DESCRIPTION OF REQUEST: Final Sign-Off for Site Plan for Building Permit

**RE: Titan Presbyterian Hotel Block – Sector Plan Map Amendment and Site Plan for Building Permit
Project #1011099, 16EPC-40085/40087**

The purpose of this letter is to explain how we have addressed Conditions of Approval for the Sector Plan Map Amendment and the Site Development Plan for Building Permit for this project, located between Central Avenue and Copper Avenue, and Mulberry Street. The project was approved by the Environmental Planning Commission (EPC) on February 10, 2017.

SITE PLAN FOR
BUILDING PERMIT

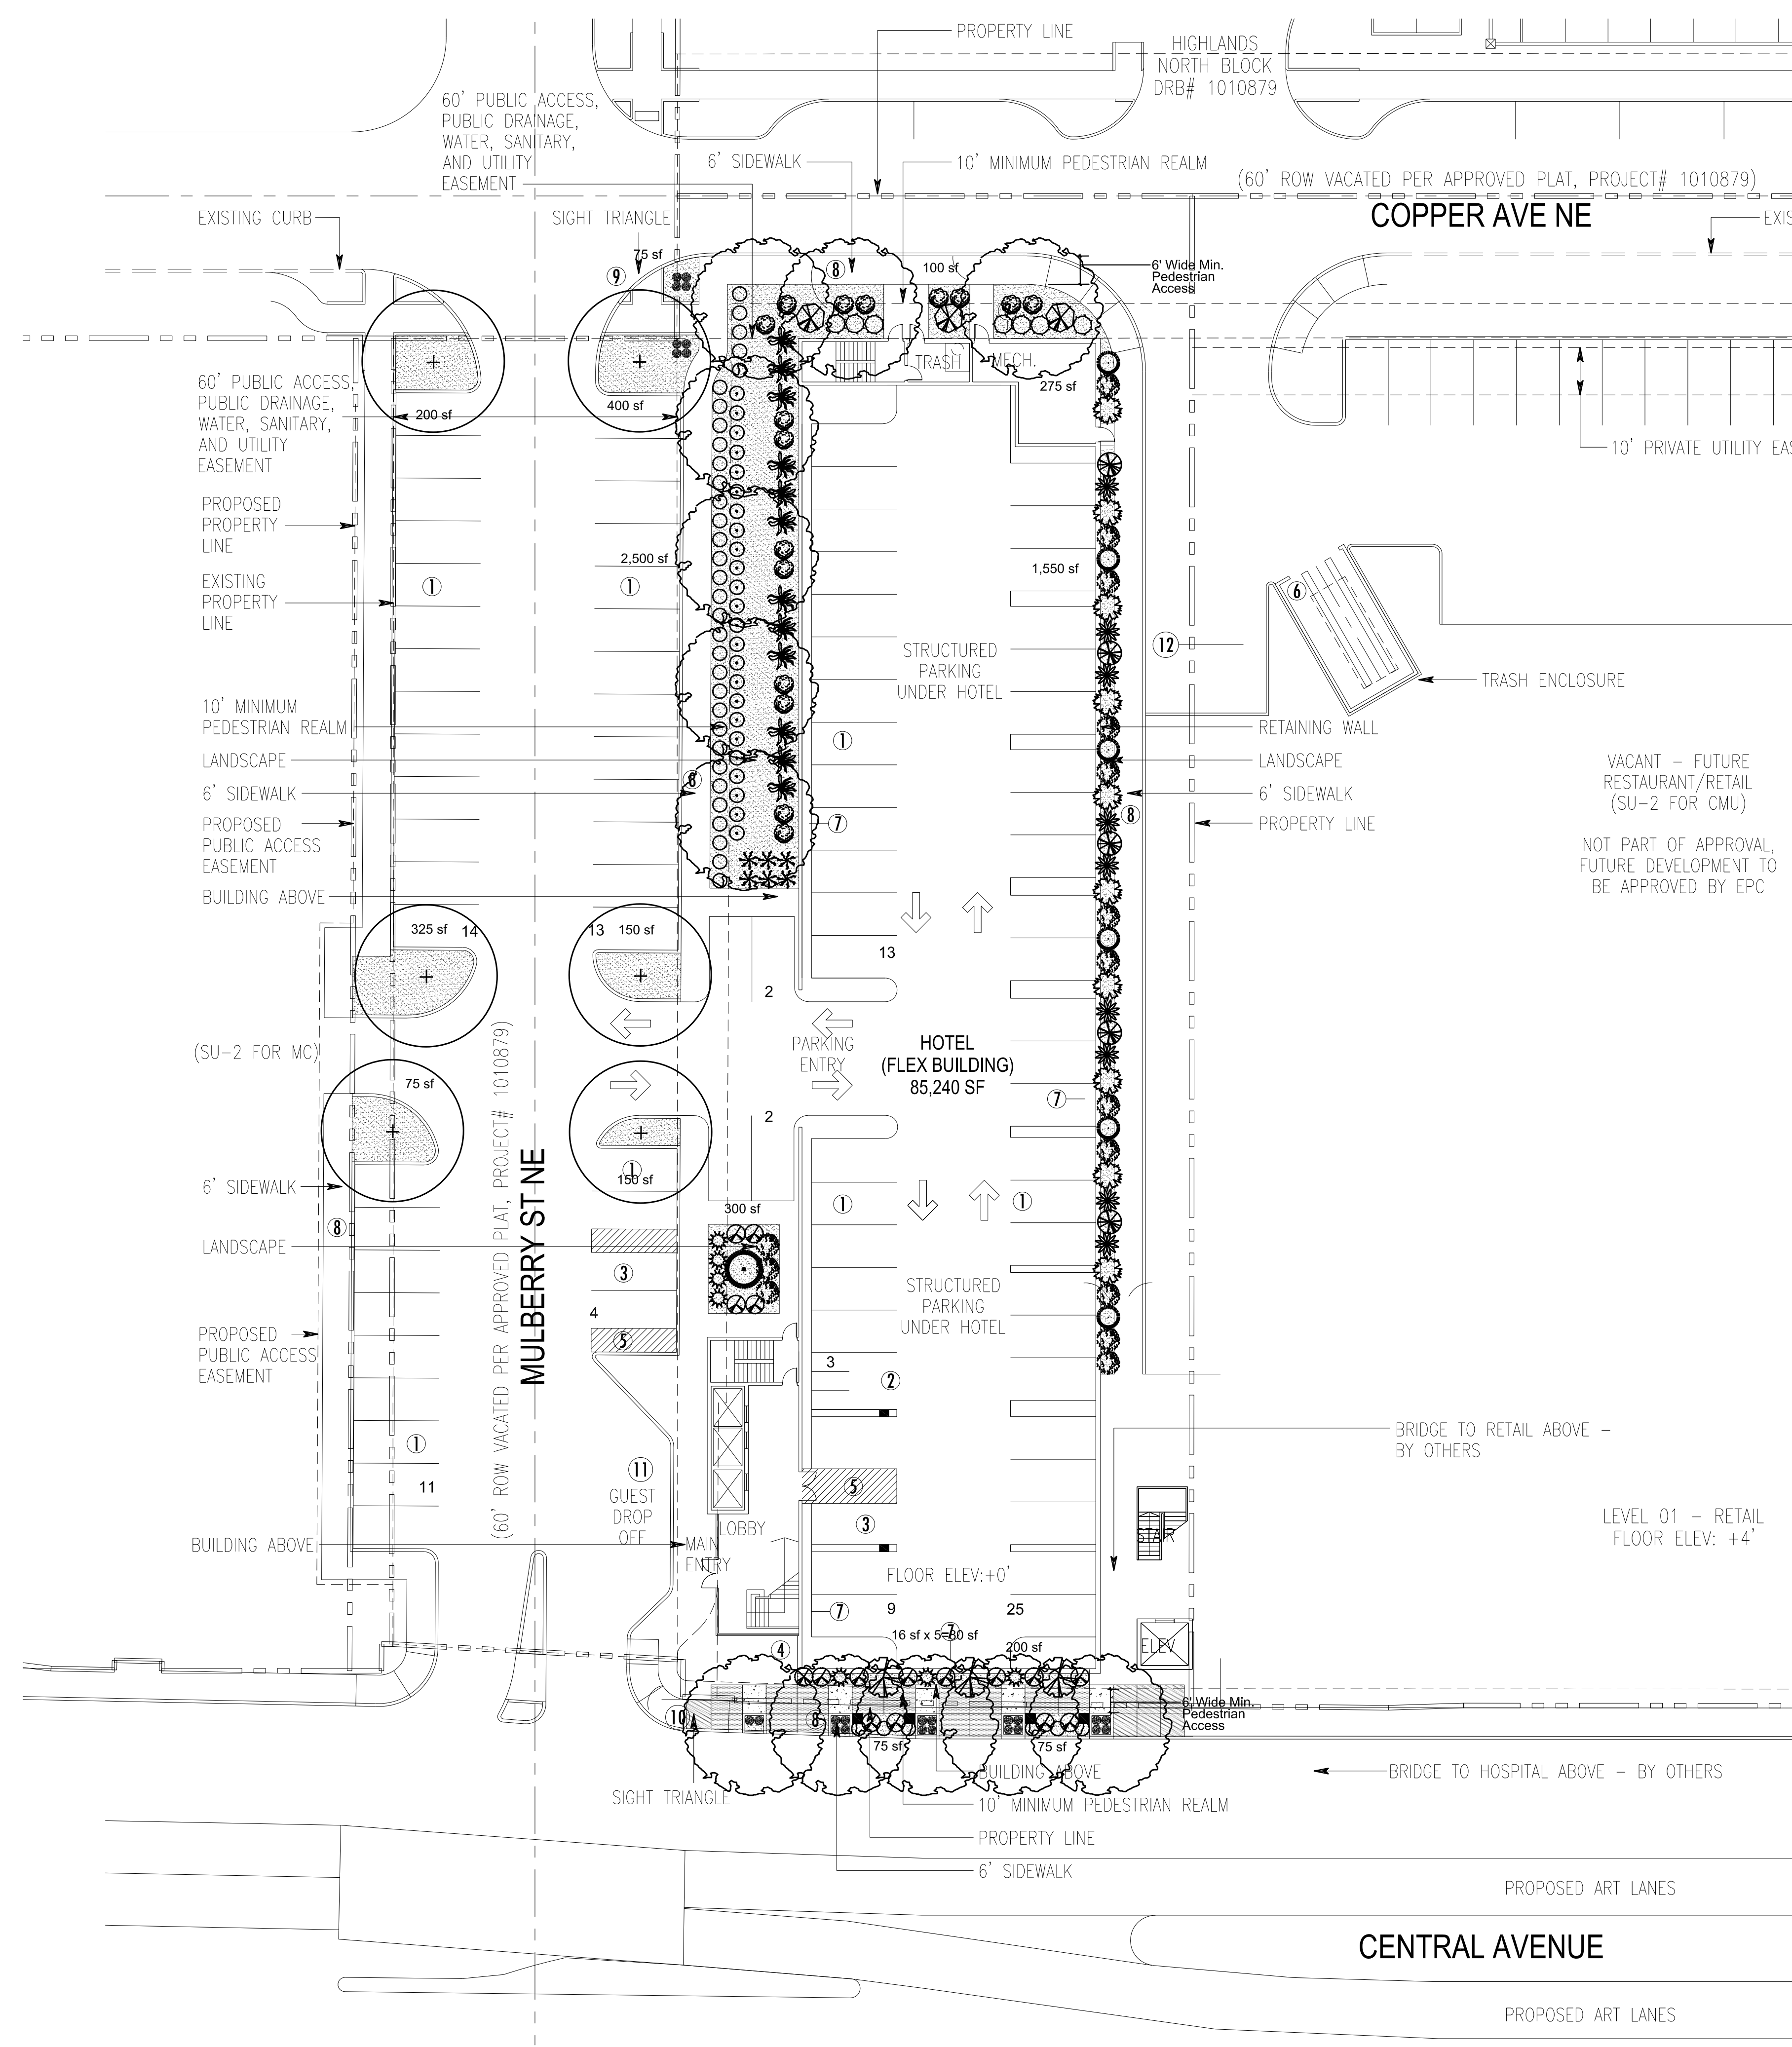
a. The section of the Zoning Code outlining the allowed 20 percent building height modification adjacent to transit shall be added to the plans.

b. The parking calculation numbers shall be updated to reflect the actual number of spaces provided.

c. Note #19 shall be updated to be a complete note on the intention to vacate adjacent rights-of-way.

4. The lighting note shall be updated to include specific references to the applicable code section 14-16-3-22(C)(6) where the requirements are found.

5. The signage note regarding future approvals shall be updated to clarify the code sections of the applicable requirements 14-16-3-22(8)(3)(n) and 14-16-3-22(C)(7).

Please see sheet 1, General Note 19 for reference to Zoning Code Section 14-16-3-22(A)(6)(B)(1)(C), outlining the allowed 20 percent building height modification.

The parking calculation numbers have been updated to include required and provided spaces for motorcycles and bicycles. Please see the first sheet of the set.

Note #19 is now note #20 and has been updated to read "Mulberry Street and Copper Avenue rights-of-way have been vacated. An Official Notice of Decision was issued by the City Planning Department on January 23, 2017 for Project #1010879, 16DRB-70447. The Plat associated with this action was recorded on June 13, 2017 for Project #1010879, 17DRB-70119."

Lighting note #17 has been updated to include specific references to the applicable code section referenced above. Please see sheet 1.

Applicable code section requirements have been added to signage note #21. Please see sheet 1.

LANDSCAPE PLAN FOR
 BUILDING PERMIT
 IMM012
 PROJECT NUMBER SHEET NUMBER

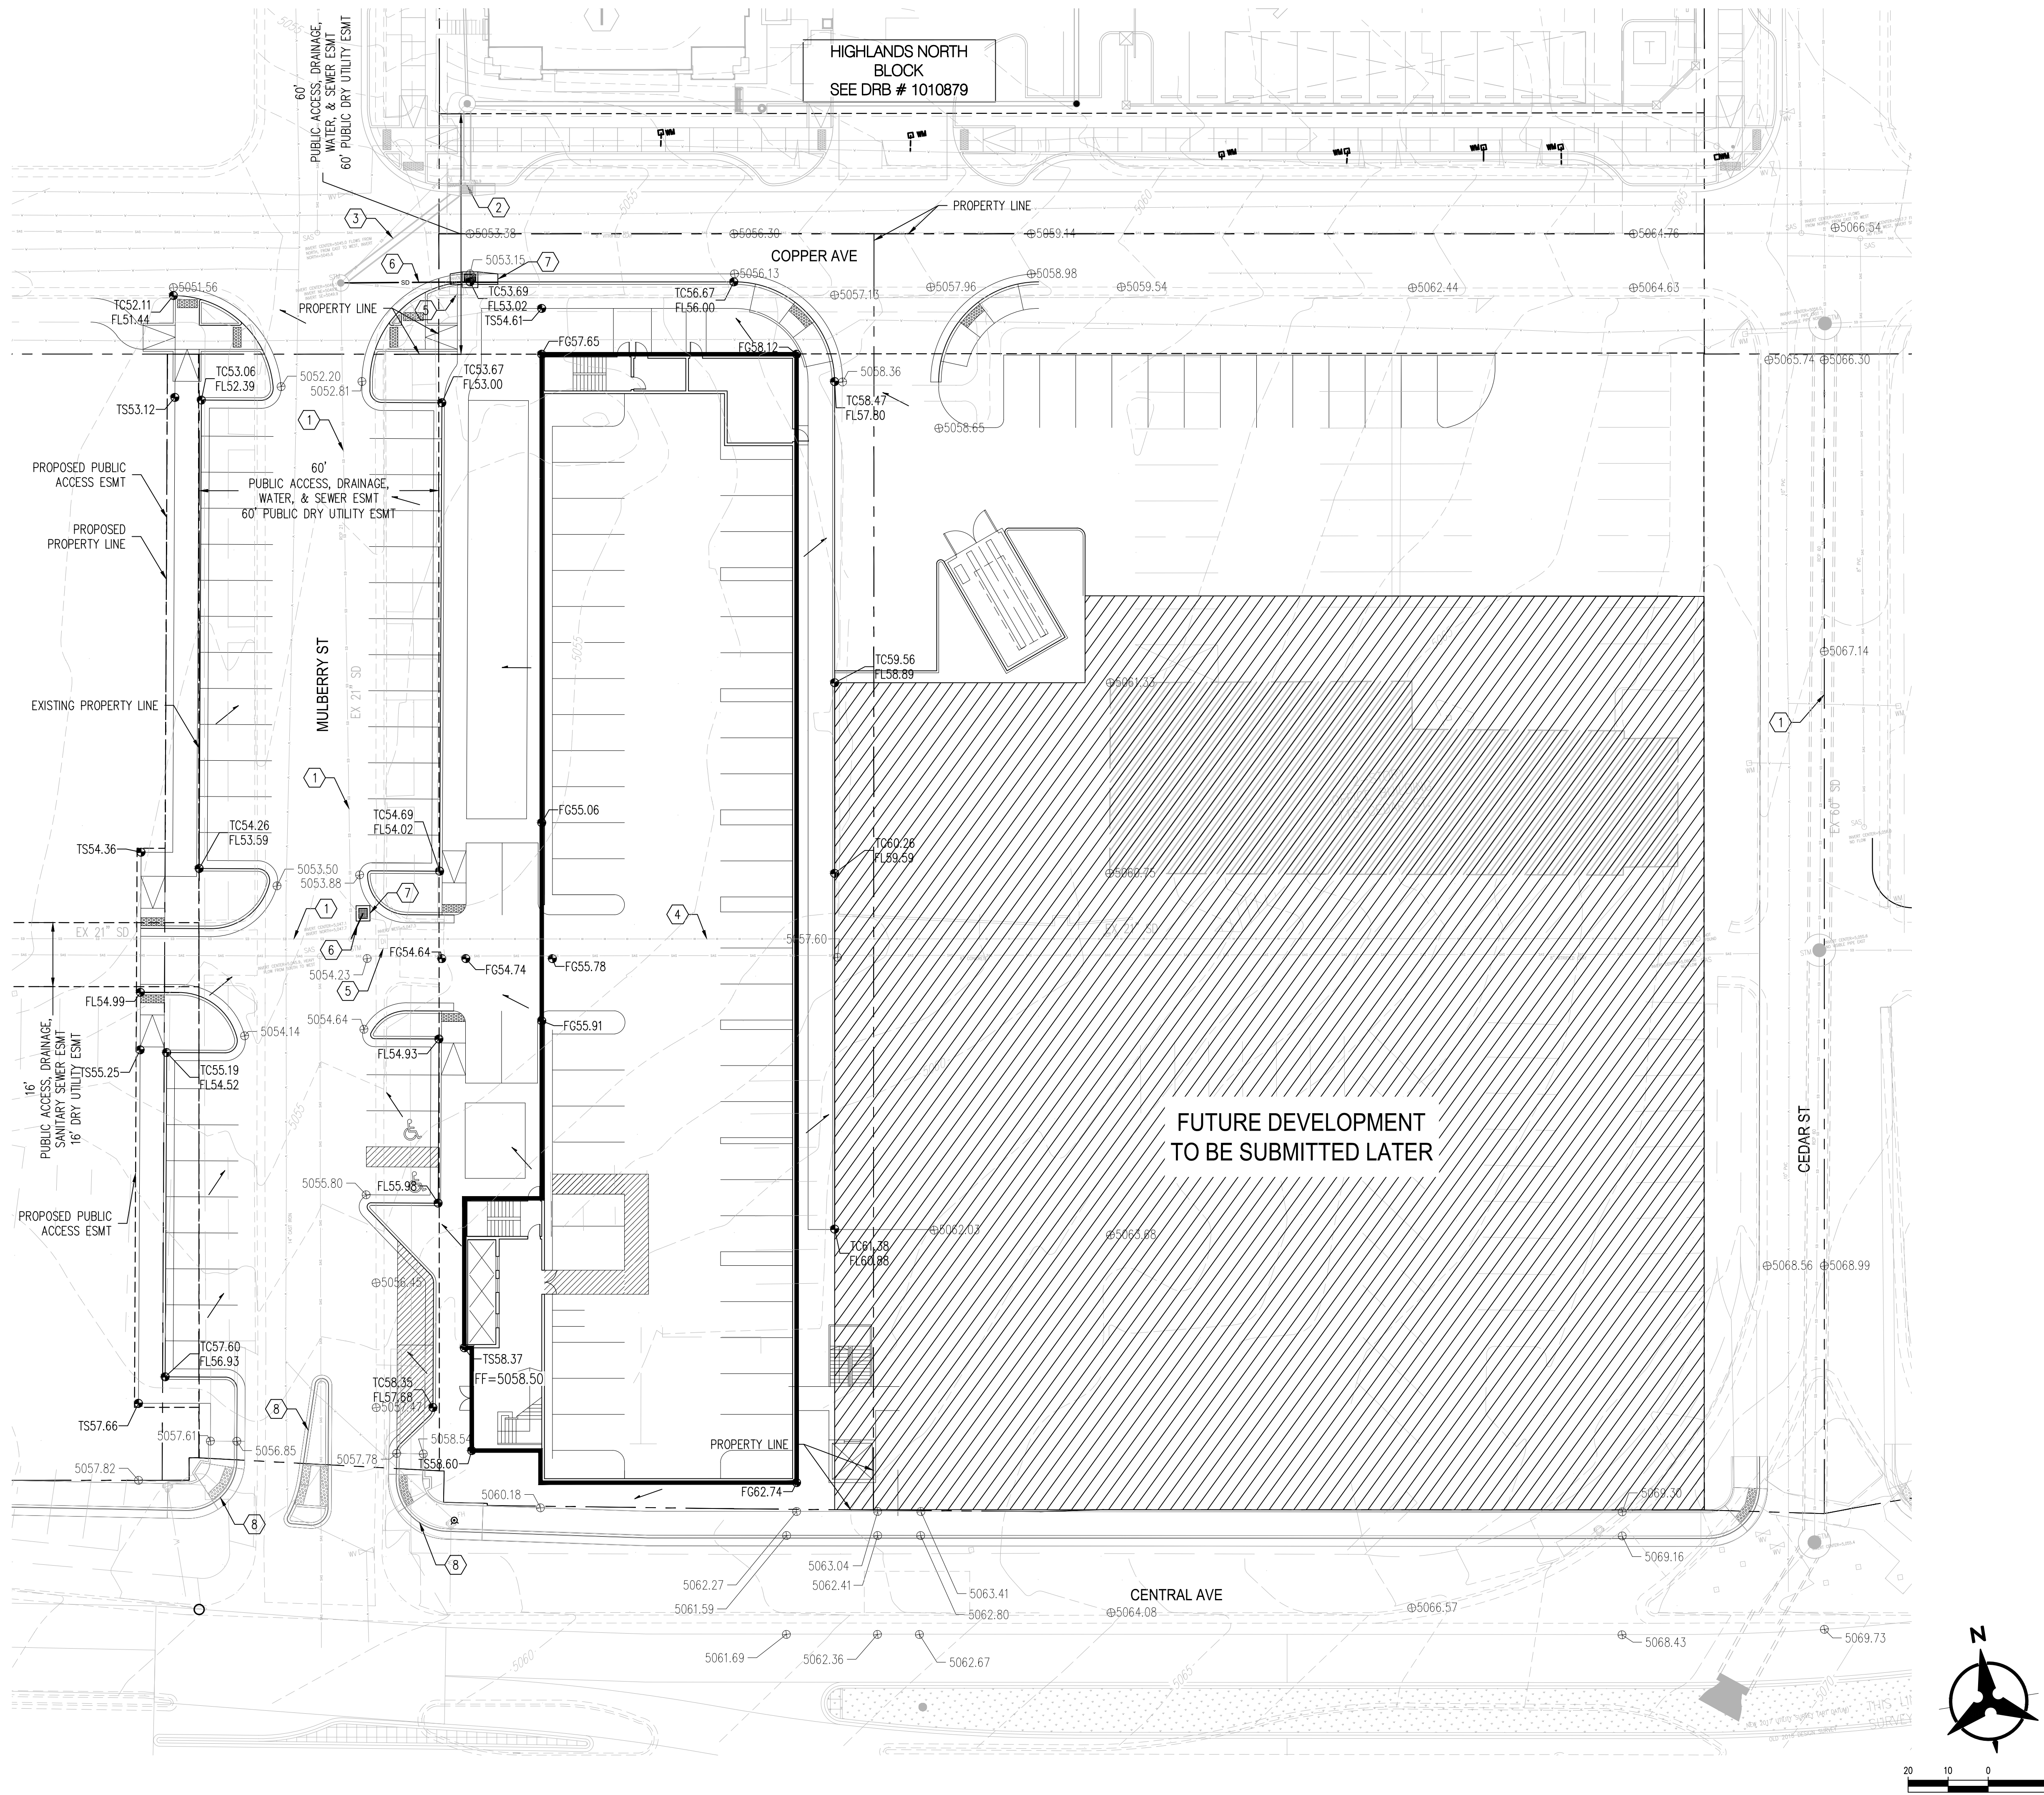
6. On the landscape plan notes, it should be noted that the plans must also comply with Zoning Code Section 14-16-3-22(C)(10) in addition to 14-16-3-10 because the Form Based Zones include specific exceptions to the basic landscaping regulations.

The landscape plan notes have been updated to meet this condition.
